**Section 96A of the Town & Country Planning Act 1990 (as amended)
Town and Country Planning (Development Management Procedure) (England) Order 2015 (as amended) - Article 10**

Non-material amendment following the grant of reference EP/148/18/HH for the addition of 1 No. round 600mm diameter white PVCu window on first floor east elevation.

86 Sea Road East Preston

PROPOSED EAST ELEVATION 1:100

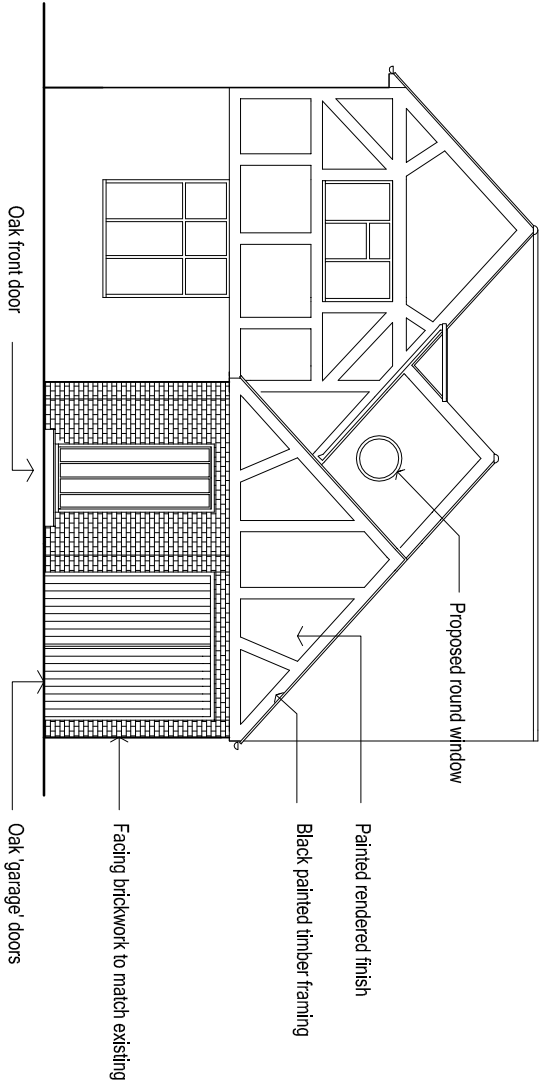
The addition of a circular window to the facade of this house represents a significant change to its appearance. We are surprised that it is being treated as an NMA. It is a very material alteration. It does not conform to the requirement of policy D DM4, that alterations should sympathetically relate to and be visually integrated with the existing building in design.

If a new window is needed to provide adequate light, it should be rectangular, and similar in design to the other windows on the facade.
